23/03428/OUT

Proposal: Outline planning application for the construction of up to 140,000 sqm of employment floorspace (use class B8) with ancillary offices and facilities and servicing and infrastructure including new site accesses. Internal roads and footpaths, landscaping including earthworks to create development platforms and bunds, drainage features and other associated works including demolition of the existing farmhouse

Location: OS Parcel 7921 South of Huscote Farm and North West Of County Boundary, Daventry Road, Banbury

Objection:

Existing Hedgerows

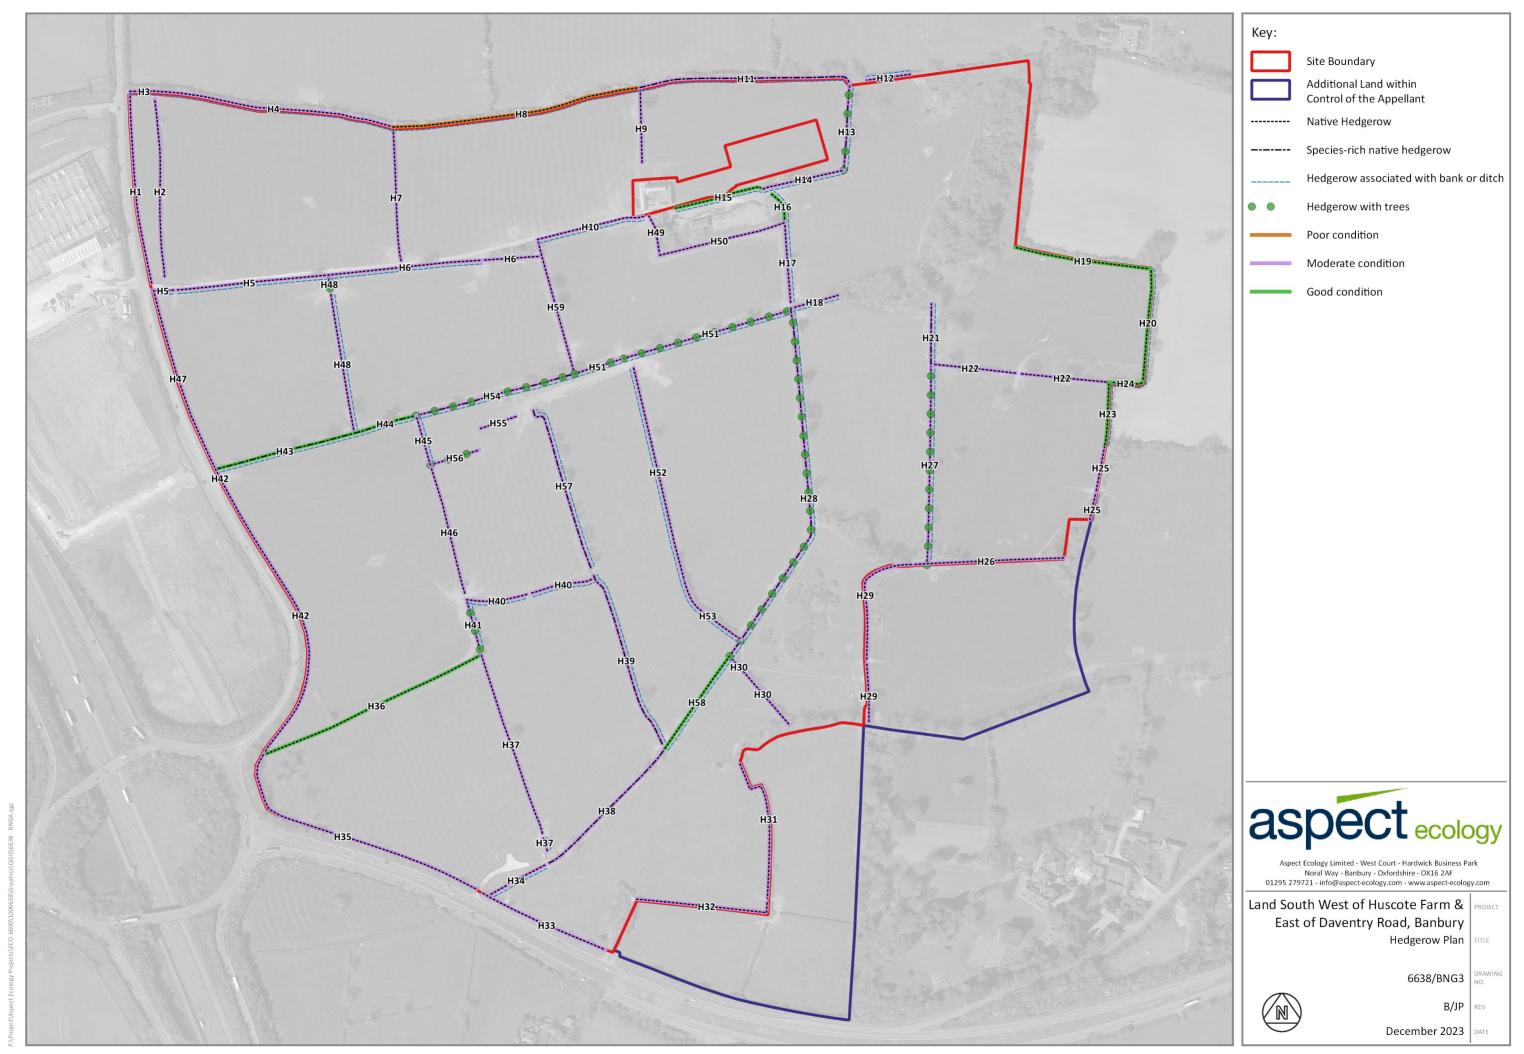
We note that the development design has considered the existing hedgerows and retains a significant proportion of them. However, we are concerned about the loss of some of the hedgerow and the impact on species dependent on the retained hedgerows. Paragraph 7.6.11 of the applicant's Environmental Statement Chapter 7 Ecology states:

We are concerned that newly created hedgerow will not compensate for impact on the retained hedgerow and the loss of hedgerow within the field system.

The Biodiversity Metric 3.1 - Calculation Tool Start page

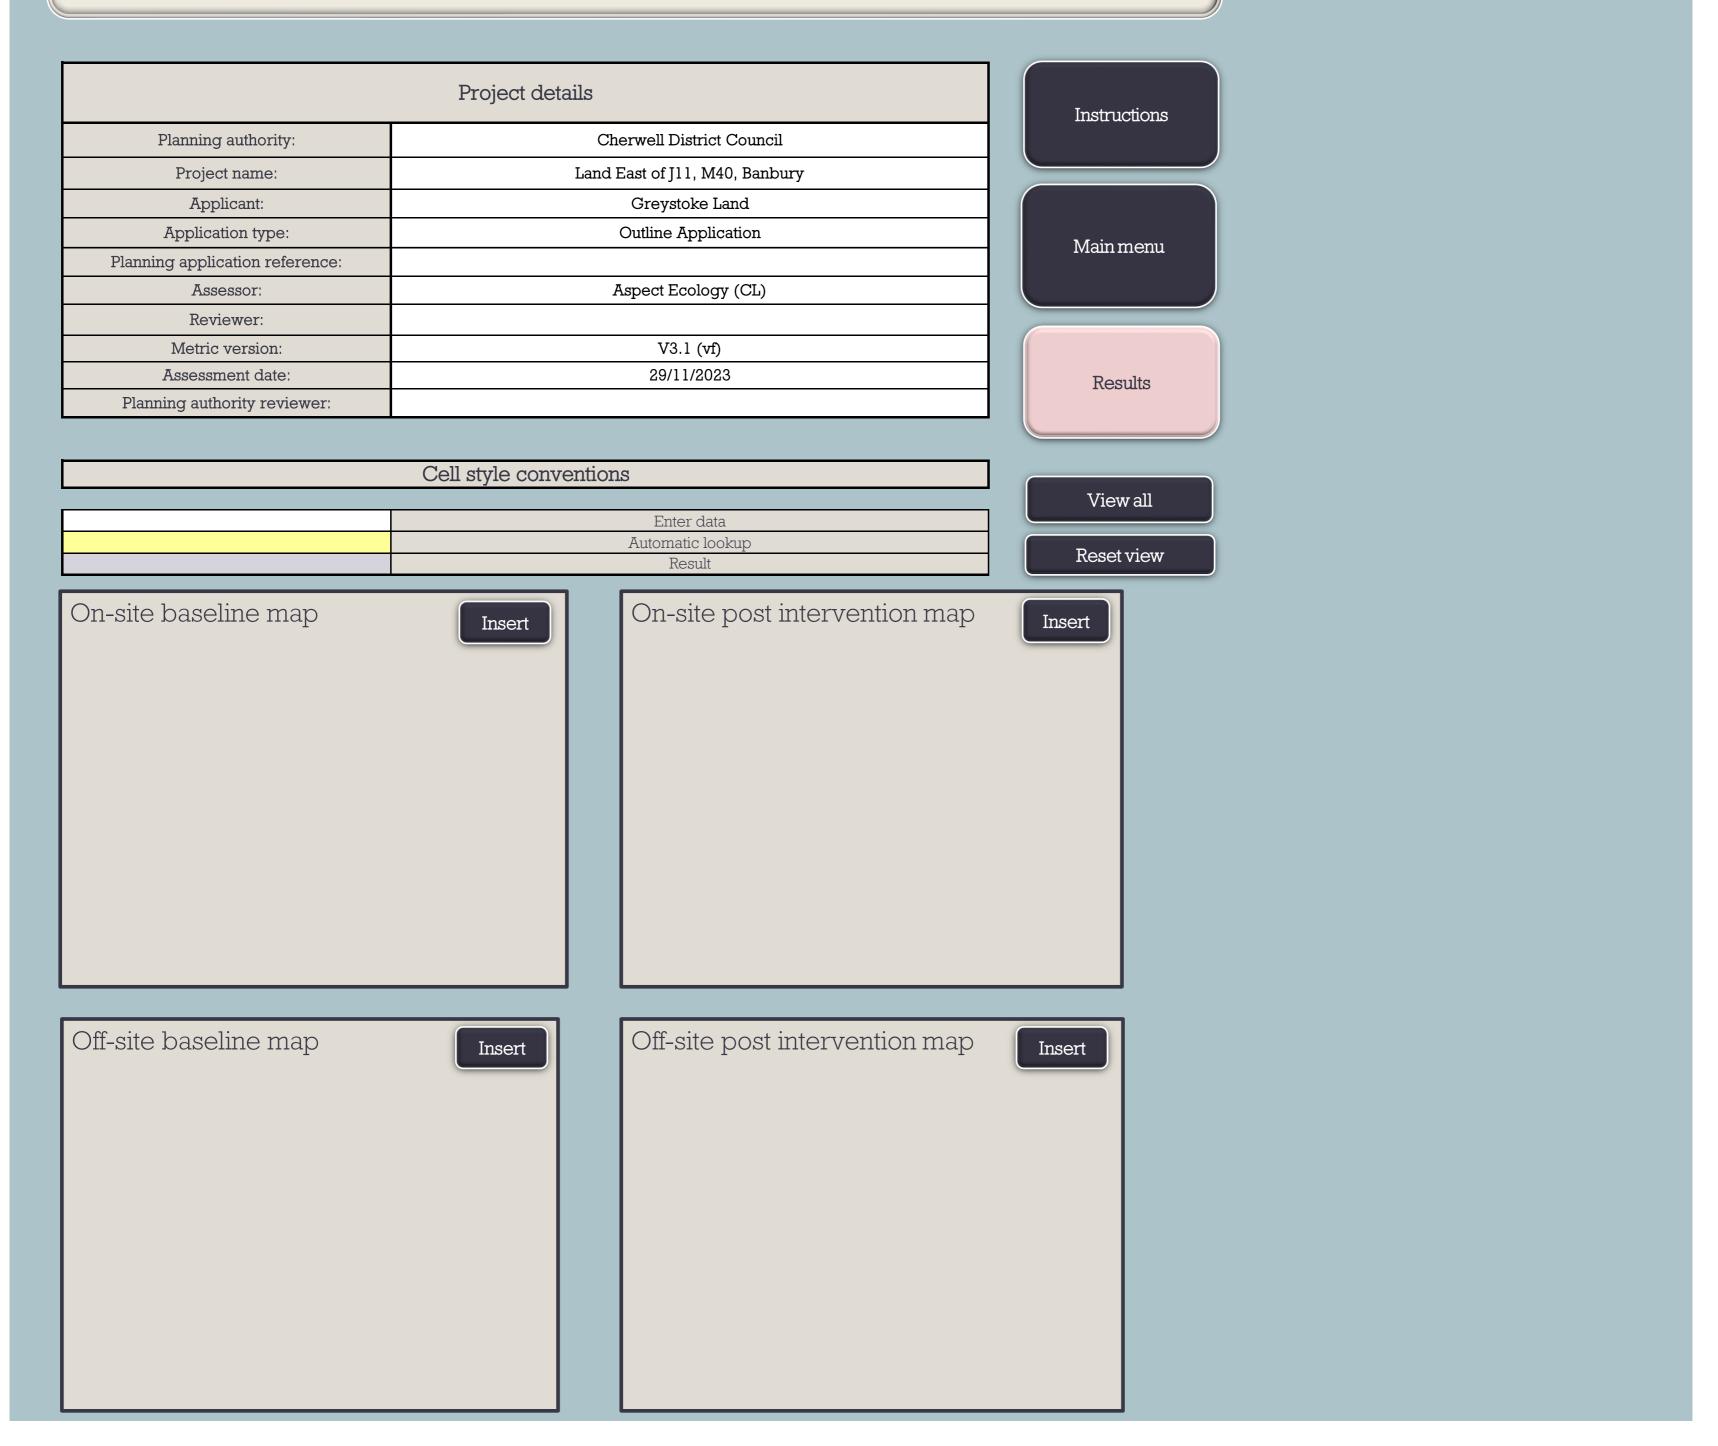
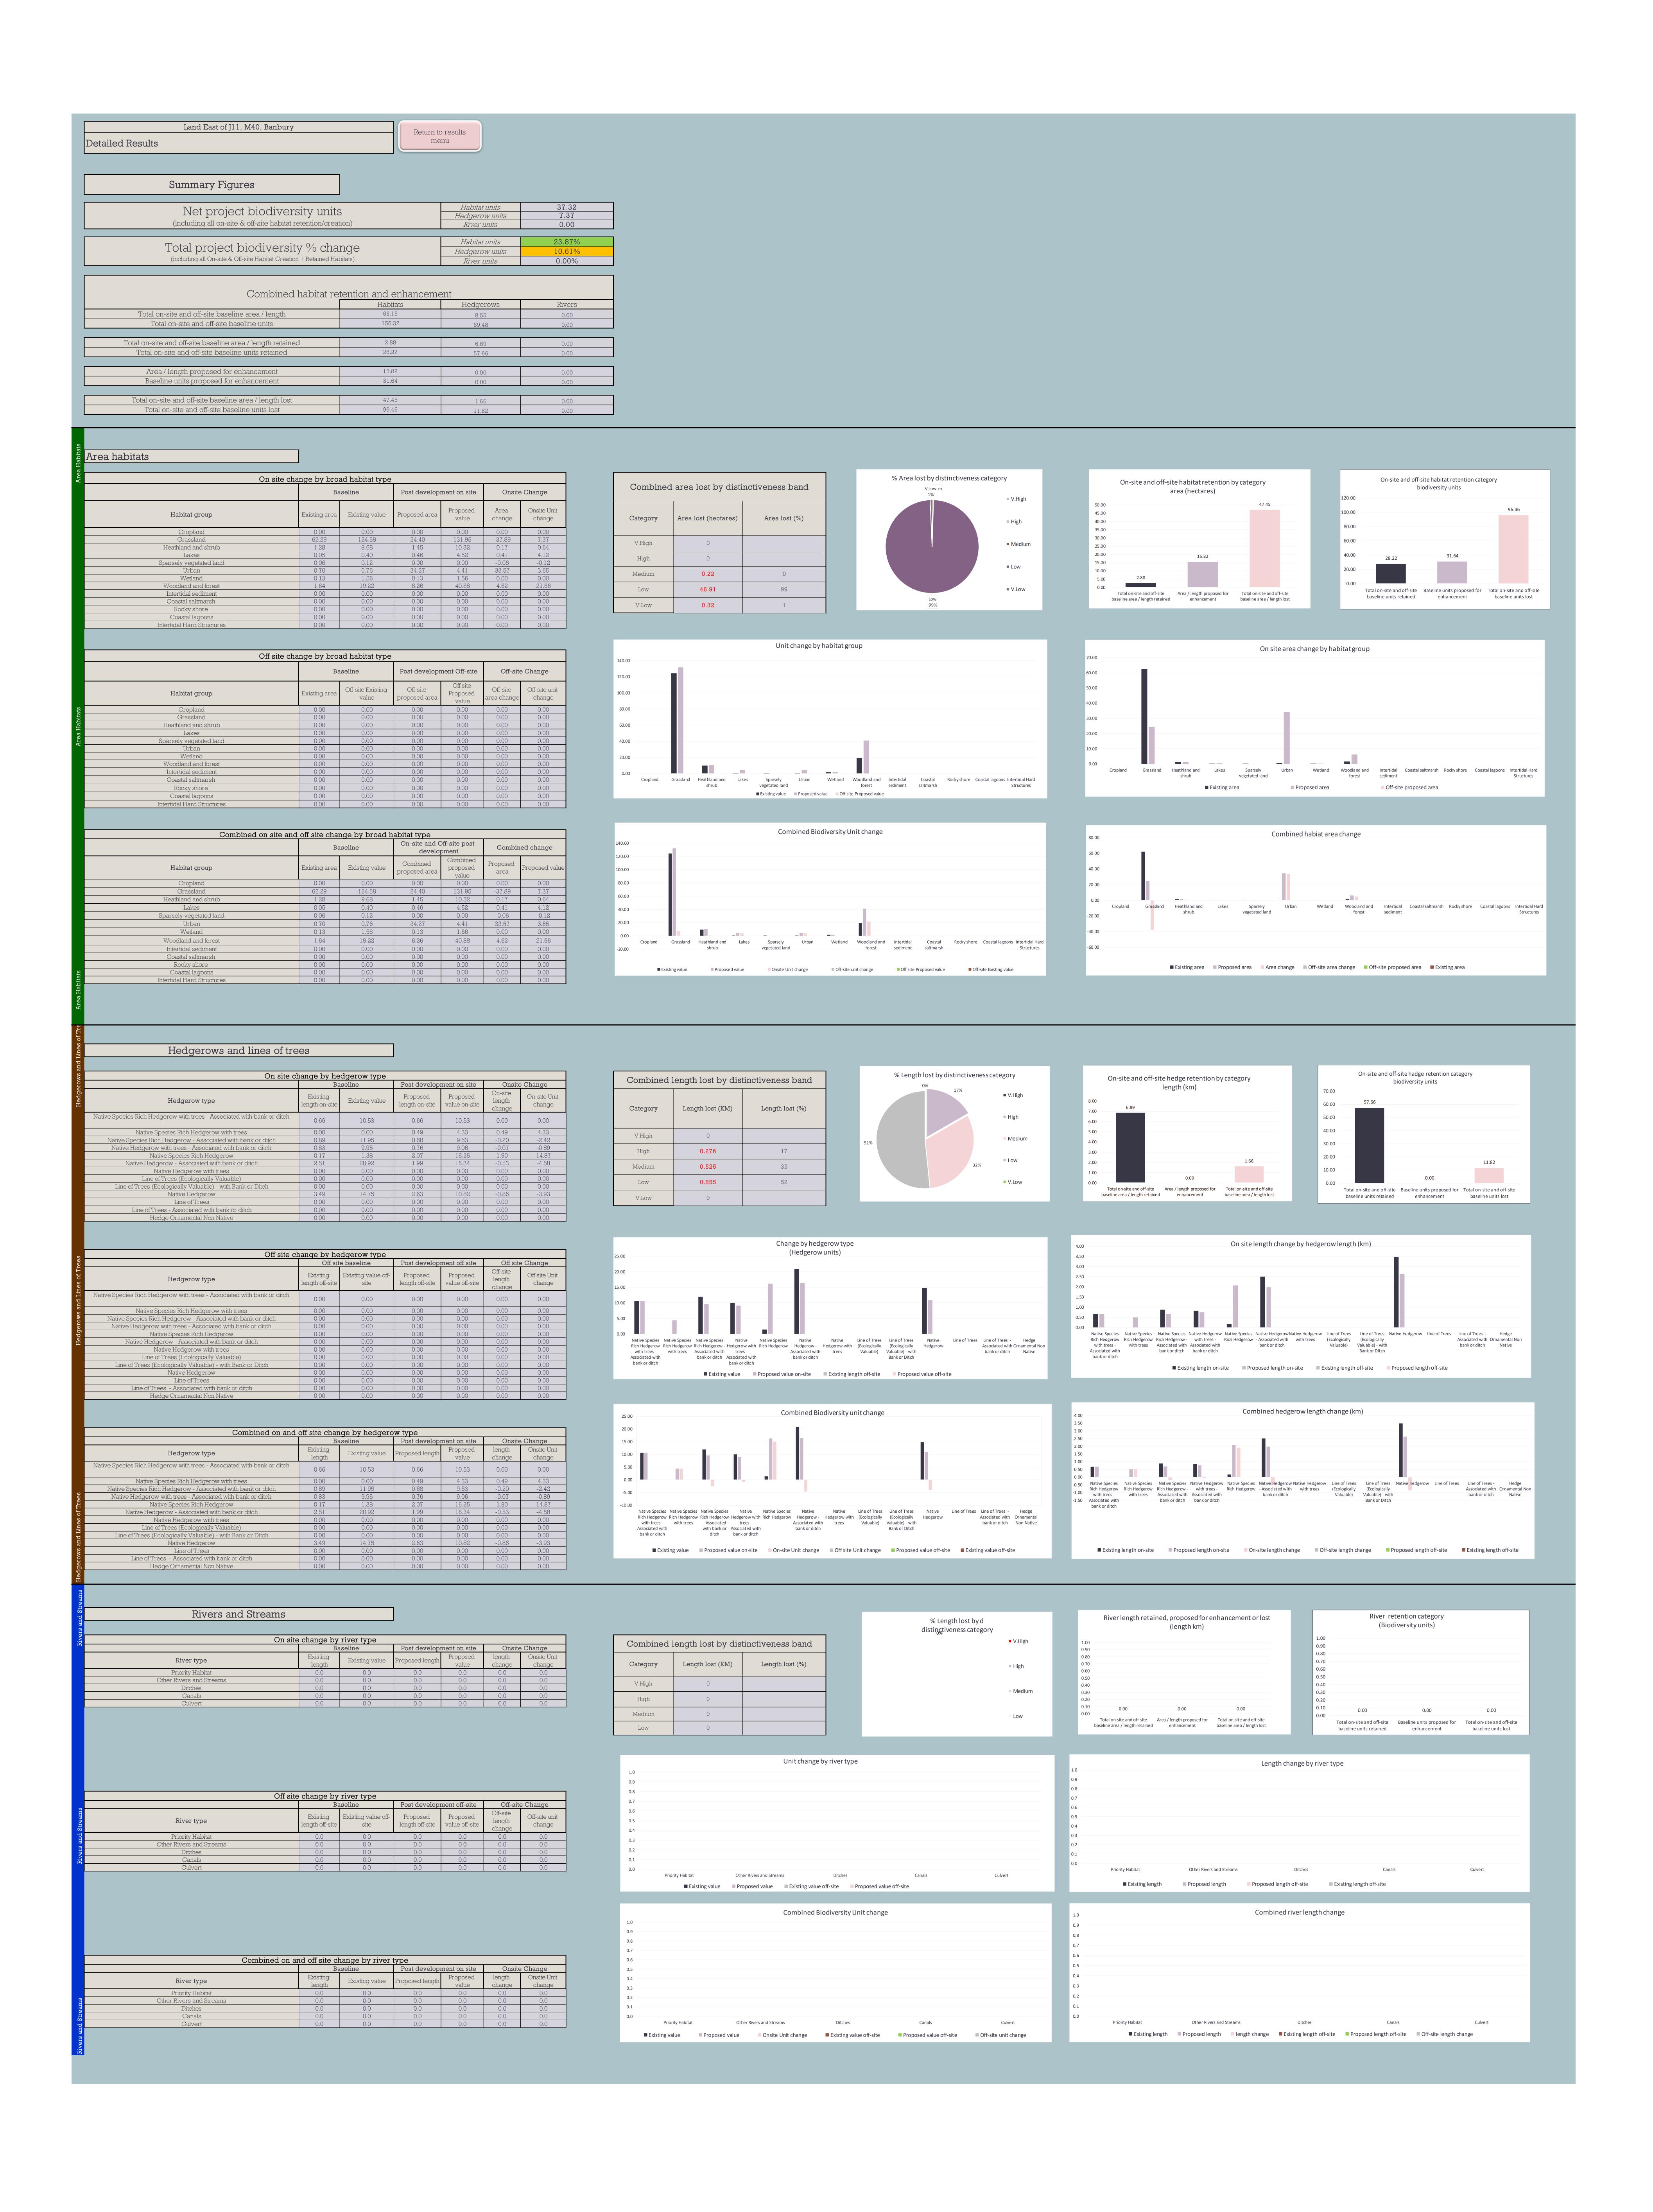
A summary of the Biodiversity Net Gain metric spreadsheet has been submitted to illustrate the potential net gain resulting from this application. This shows a net gain of 23.87% habitat units and 10.61% hedgerow units.

We welcome the submission of the summary metric but it appears that the summary relating to site habitat enhancement has been omitted and we would also request that the full excel spreadsheet is submitted to allow a complete analysis of the calculation.
